## WEST SUSSEX COUNTY COUNCIL CONSULTATION

| <b>LOCATION:</b>           | 1A Normanton Avenue<br>Bognor Regis<br>PO21 2TX                                                    |
| <b>SUBJECT:</b>            | BR/208/25/S73<br>Variation of condition 2 imposed under<br>BR/49/25/HH relating to approved plans. |

SITE PLAN - 1/500

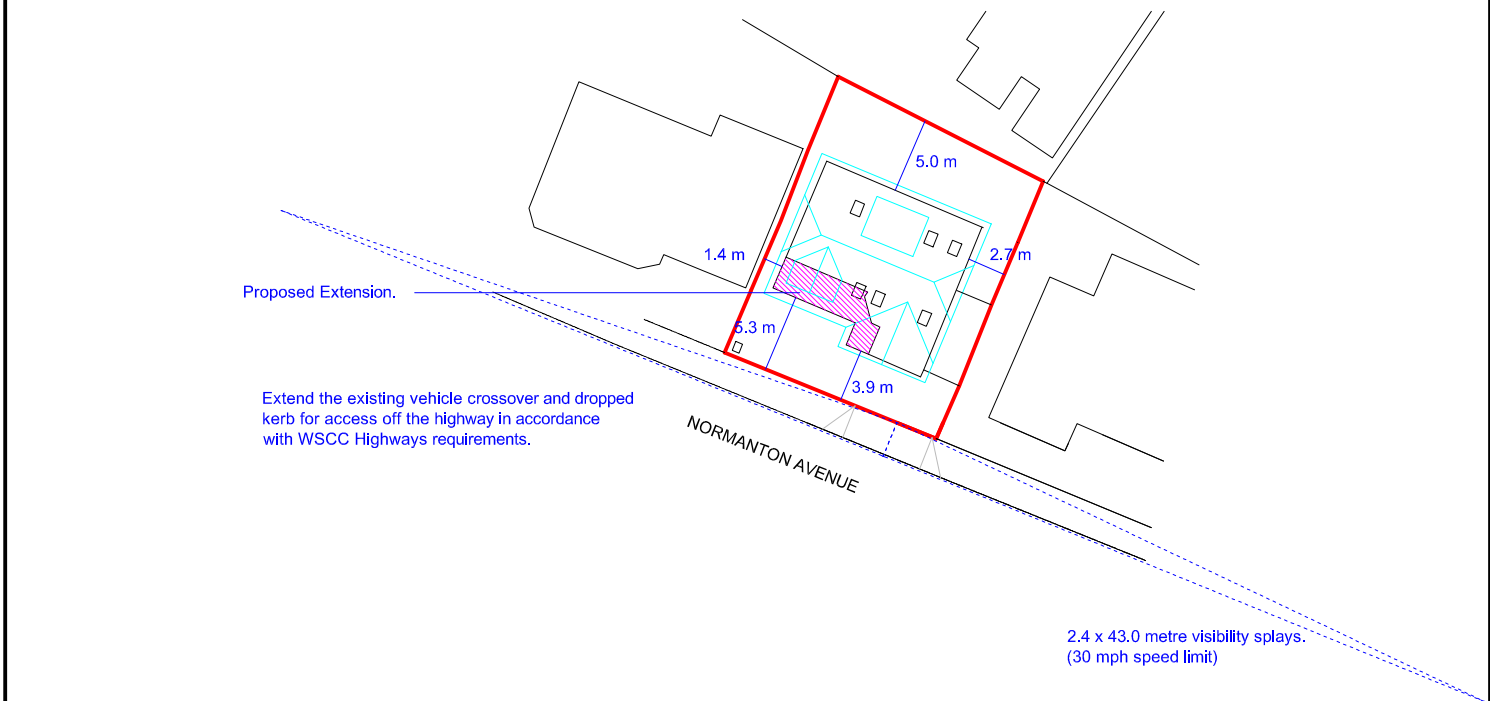
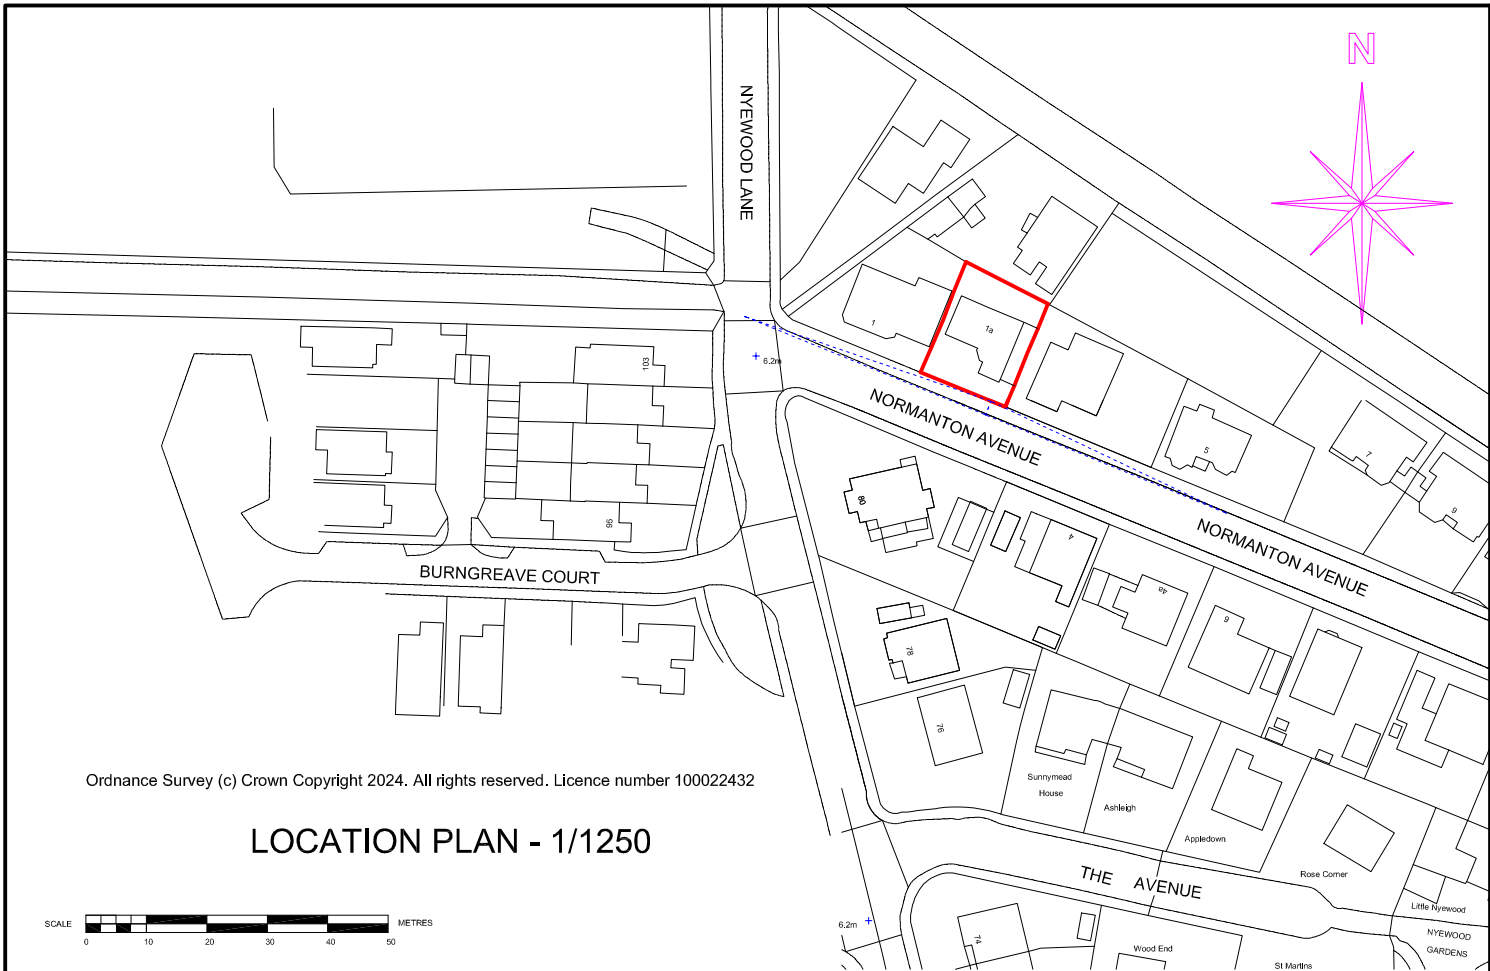
No concerns from the LHA's perspective to the proposed extension. The applicant should liaise with the LHA's Local Engineer (contact attached within Informative) on the width of the crossing point which is shown as being extended. Ideally this should be no wider than 6.4 metres. From a highway safety perspective however, we would be satisfied this would not have a 'Severe' impact in line with NPPF guidelines.
